**Our Ref: WA/20/13/
Your Ref:**

Application for Planning Permission for Works or Extension to a Dwelling

Development Conversion of existing stable block into residential 1 bedroom annexe to accommodate a dependent relative

Location The Farmhouse Eastergate Lane Walberton

AREA 2 HA
SCALE: 1:1250
CENTRE COORDINATES: 496054 , 106182

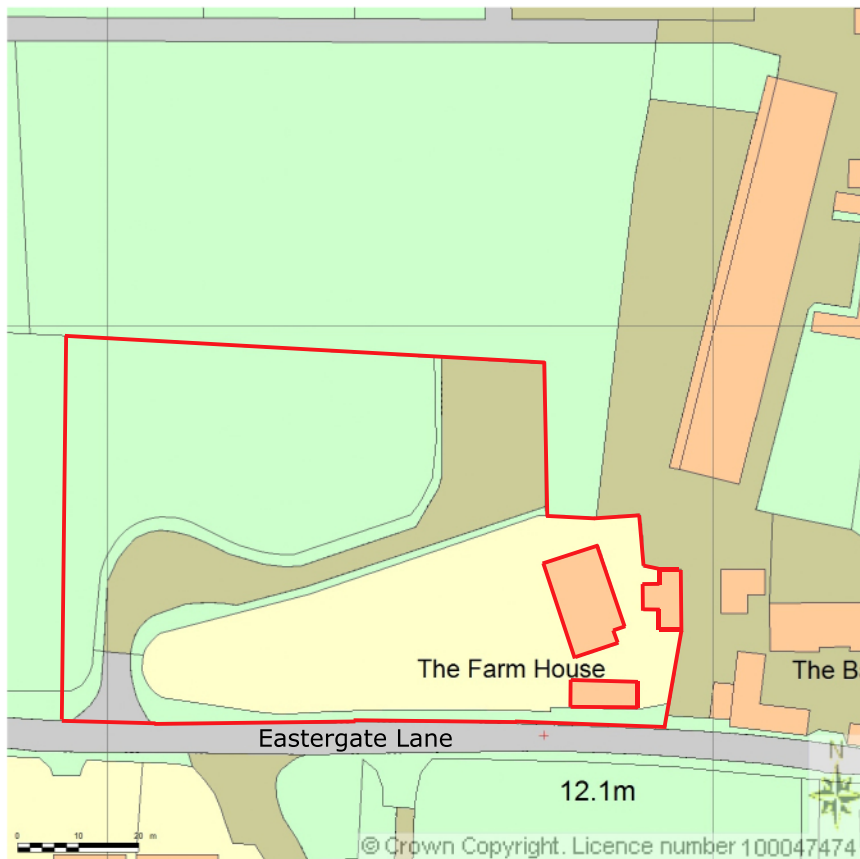
Please submit 1 electronic or 3 paper copies of a revised location plan with an additional named road and with the site clearly red edged in accordance with the guidance notes available on our website detailed below (click on National List).

EXISTING FLOOR PLAN

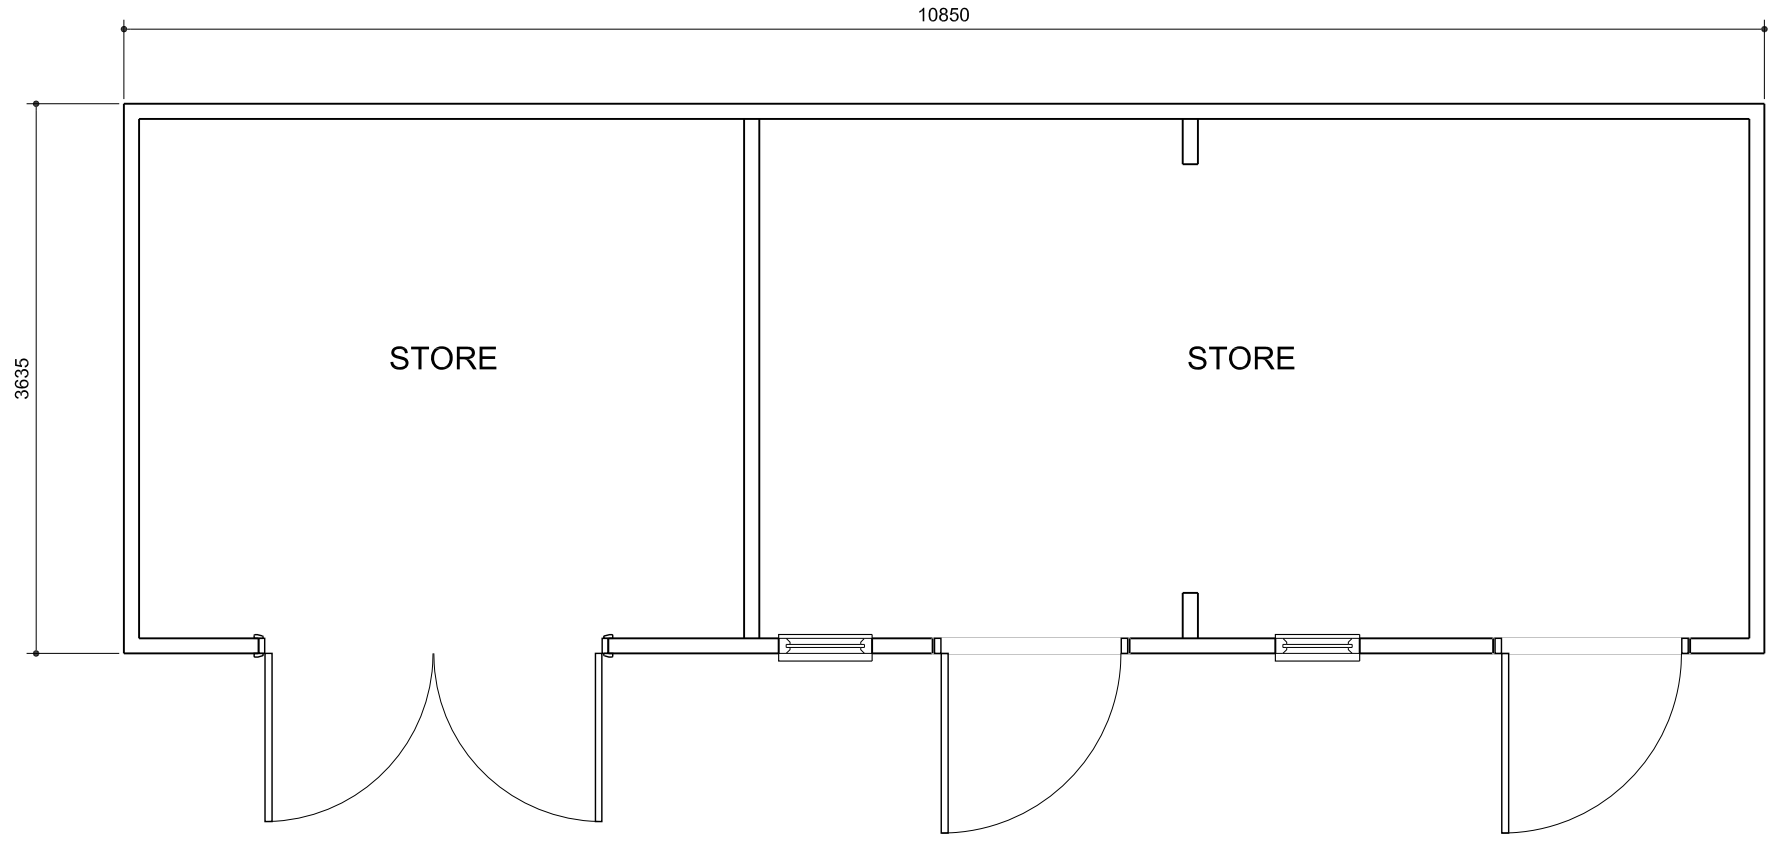
Please submit 1 electronic or 3 paper copies of revised existing floor plans with all windows indicated clearly to match the elevations at a scale of 1:50 in accordance with the guidance notes available on our website detailed below (click on National List).

EXISTING ROOF PLAN

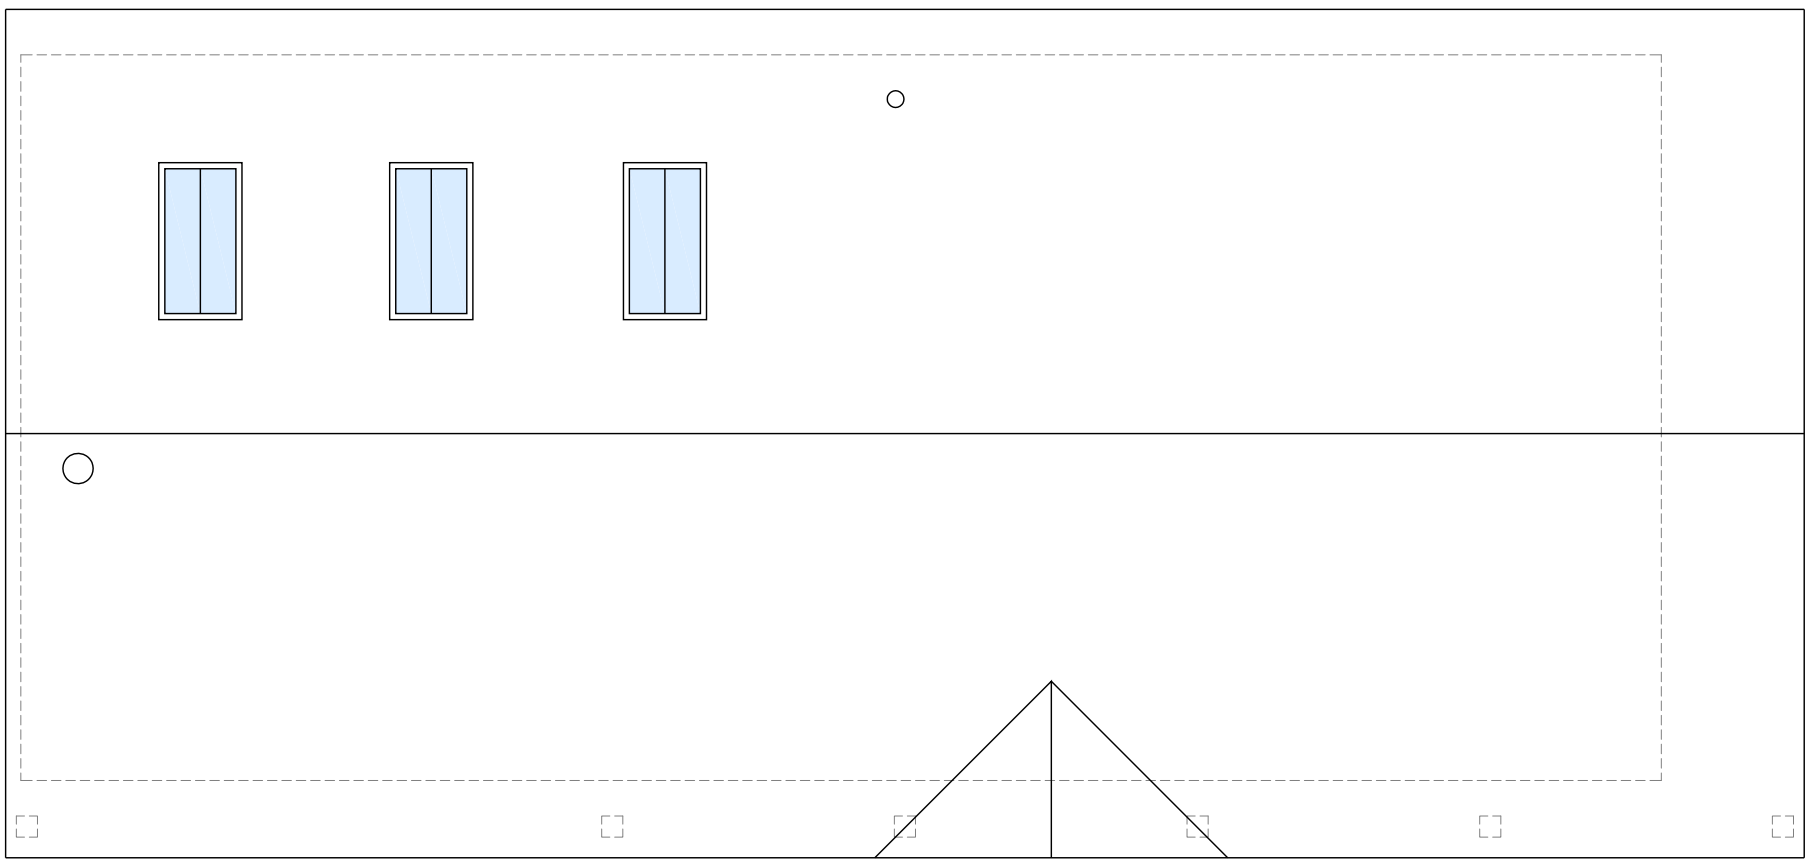
Please submit 1 electronic or 3 paper copies of existing and proposed roof plan in accordance with guidance notes available on our website detailed below (click on National List).
